LOCATION 21 Haskell St

New Single Family Dwelling-26x34
with garage

TO: Inspections
FROM: Jay Reynolds, Development Review Coordinator
DATE: June 6, 2002
RE: C. of O. for # 21 Haskell Street
Lead CBL (339F012) ID# (2001-0317)

**FLOOR PLAN-FIRST FLOOR**

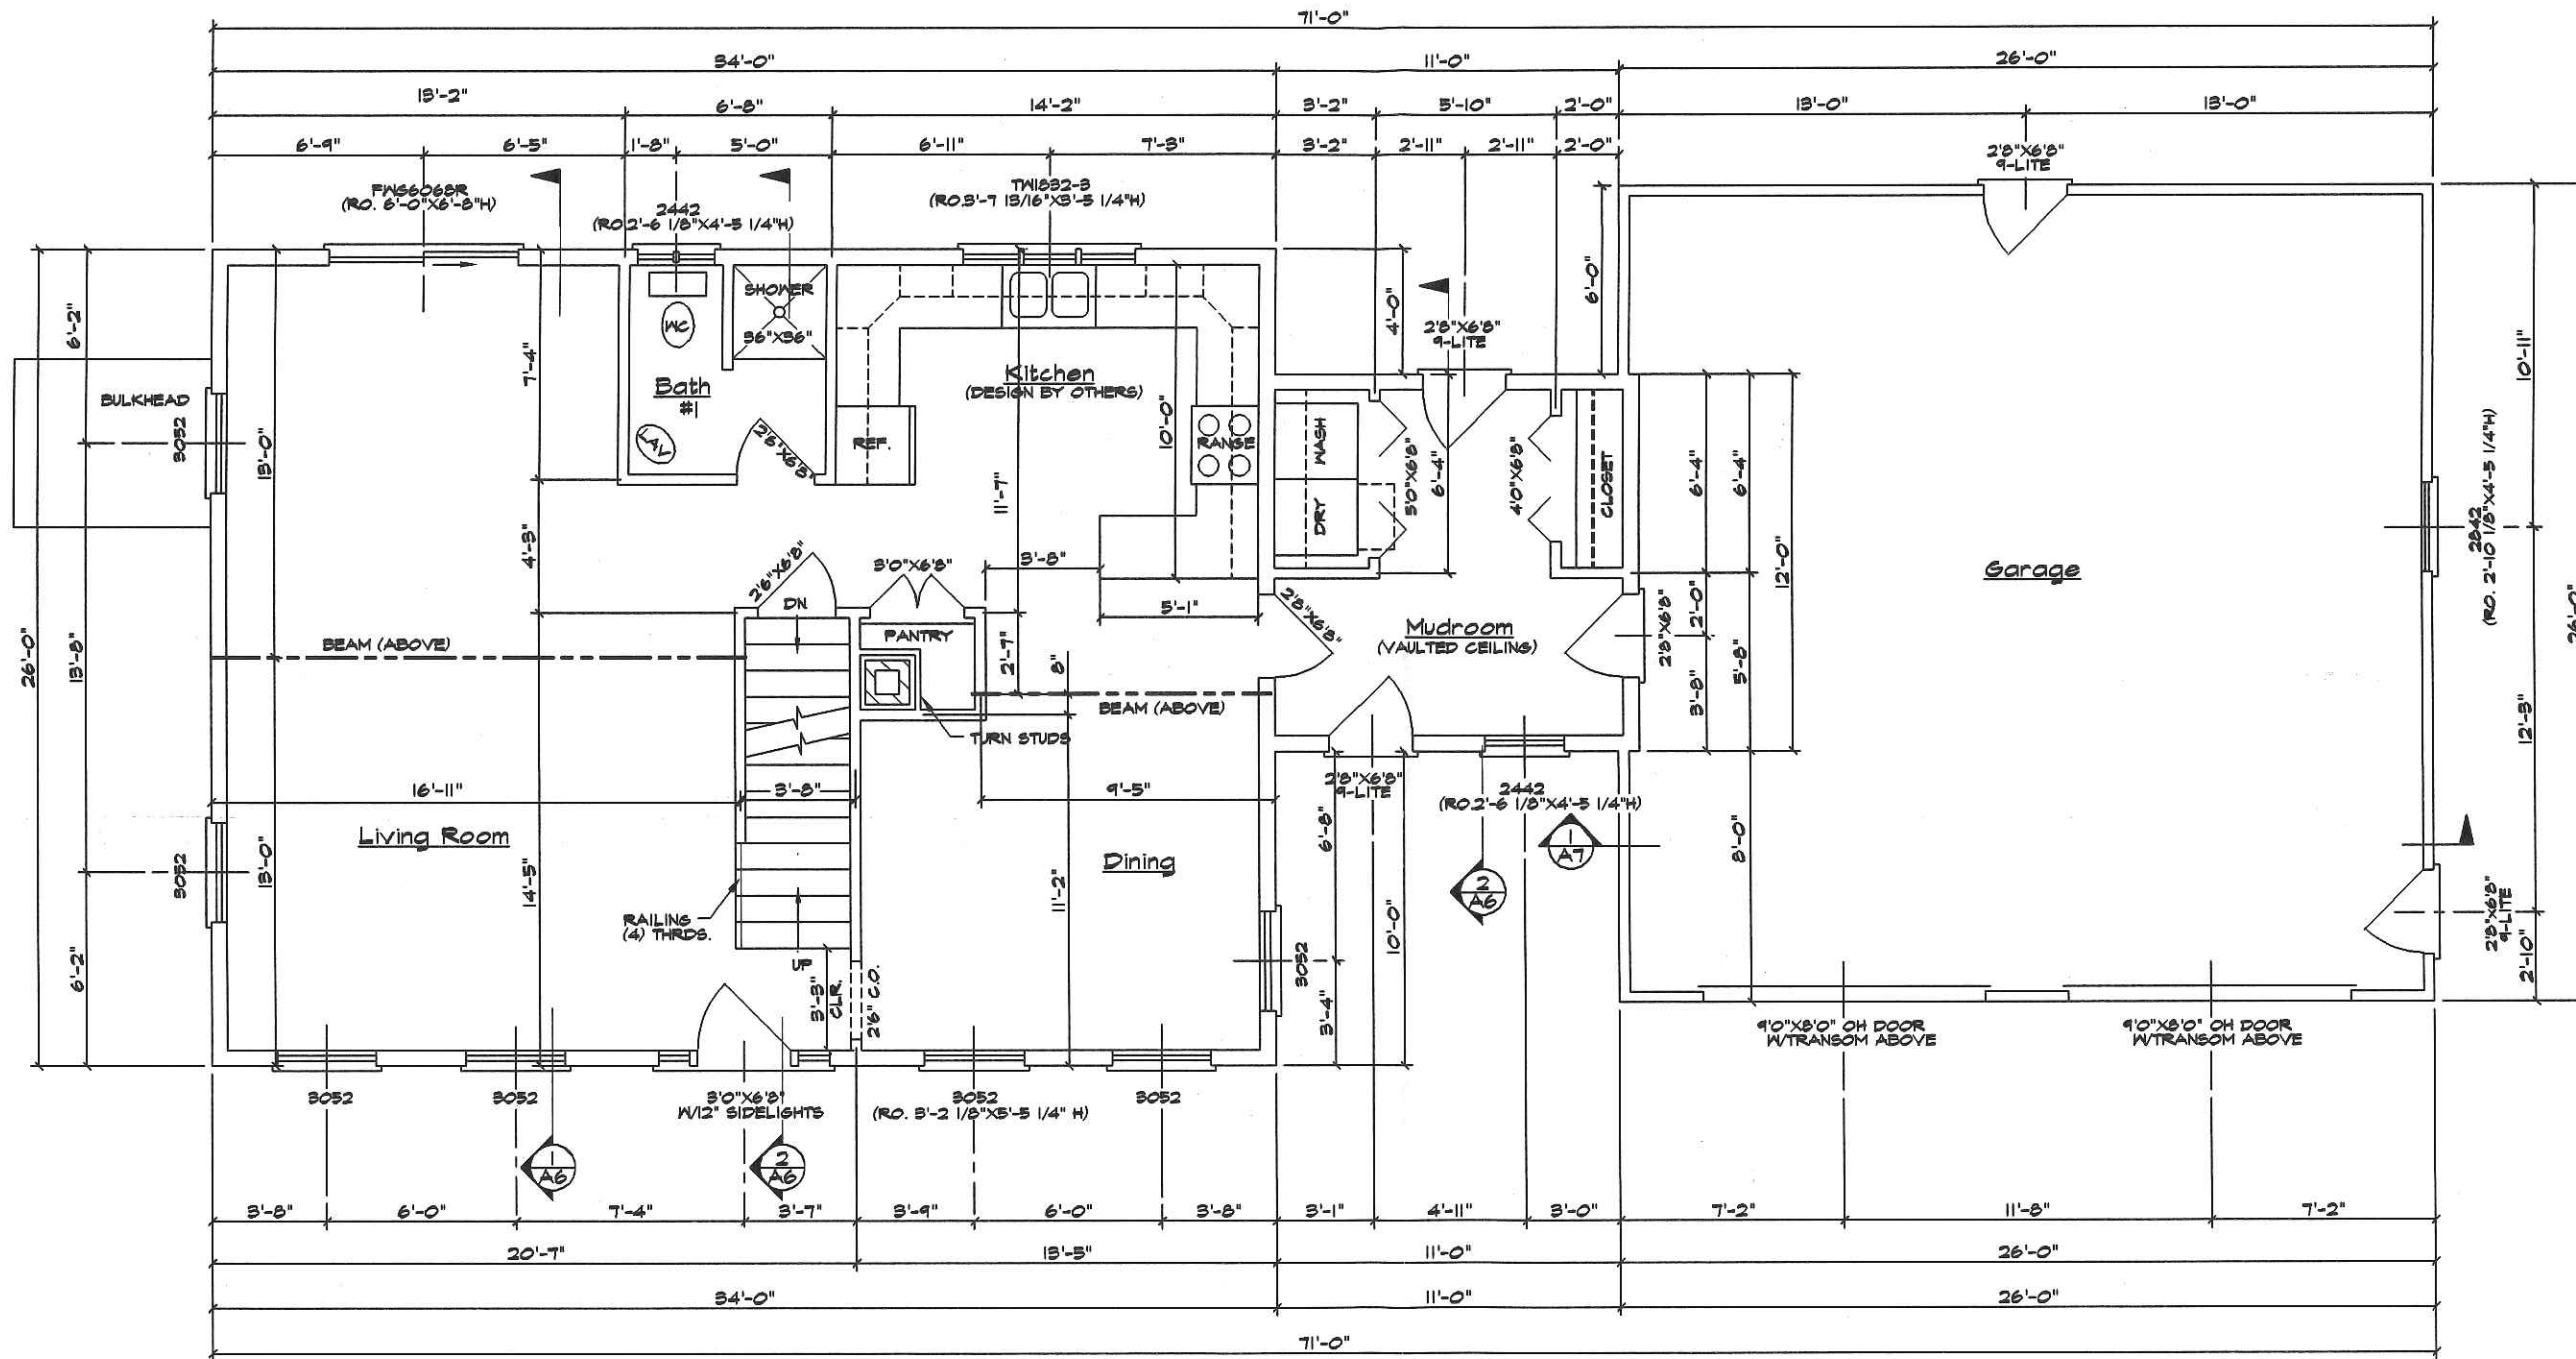
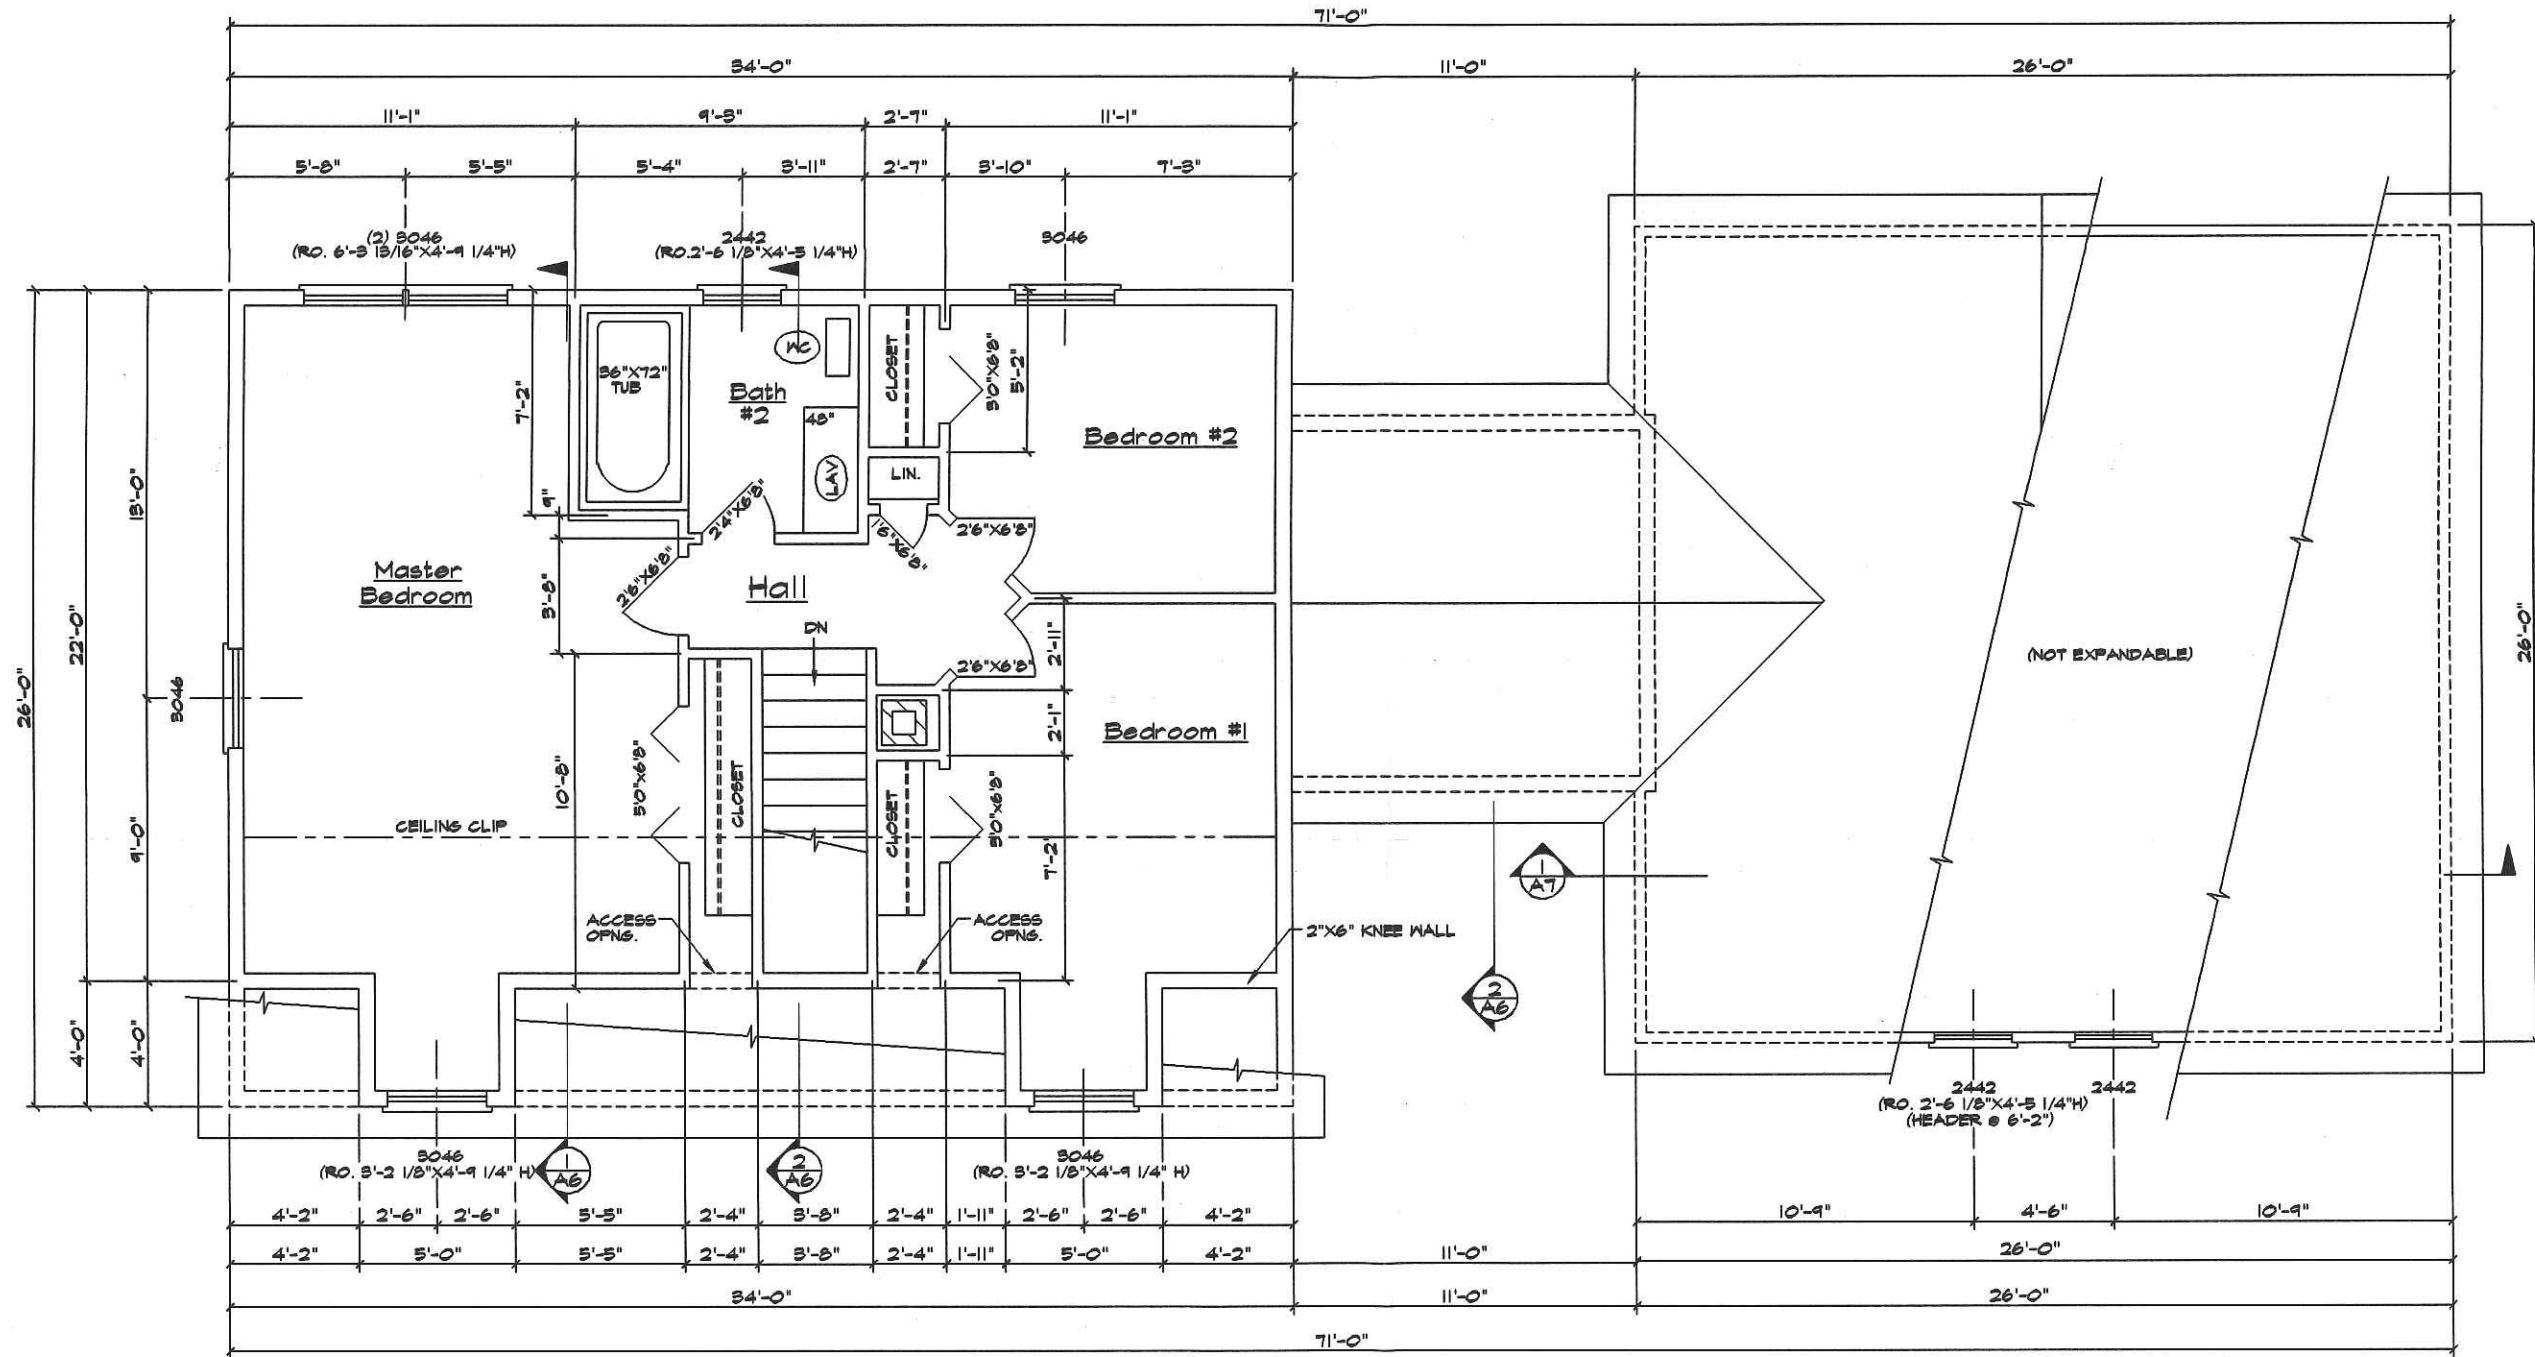
3/14/02 Close in inspection. OK to close for plumb/elect. also Some code issues to resolve:

- Need to check chimney Flashing - told not to close in
- Head room on main stairway will not be 80" when 5 Rock applied
- Egress windows need adjustment ONLY 22 1/2 x 33 1/8
- Cellar stair Headroom Not 80" ~~R~~ Treads only 9 1/2" Risers are open
- Need joist hangers in Basement & Garage
- Scuttle only 16" x 30"
- Will need spec on Steel Beam - Garage 2nd stairs not in - only for storage
- Deck on 2nd FL Master BR not Framed
- Using Lumber for garage Rafters - NOT TRUSSES (2x10) need Collar ties.

6/4/02 Final inspection w/ Jim White. All above issues have been corrected. Still need to close in open RISERS and correct Rise on 1 EXTERIOR (FRONT) TREAD. JR

6/6/02 Above issues all set, REC'D memo FROM Jay Reynolds. READY FOR C/O JR
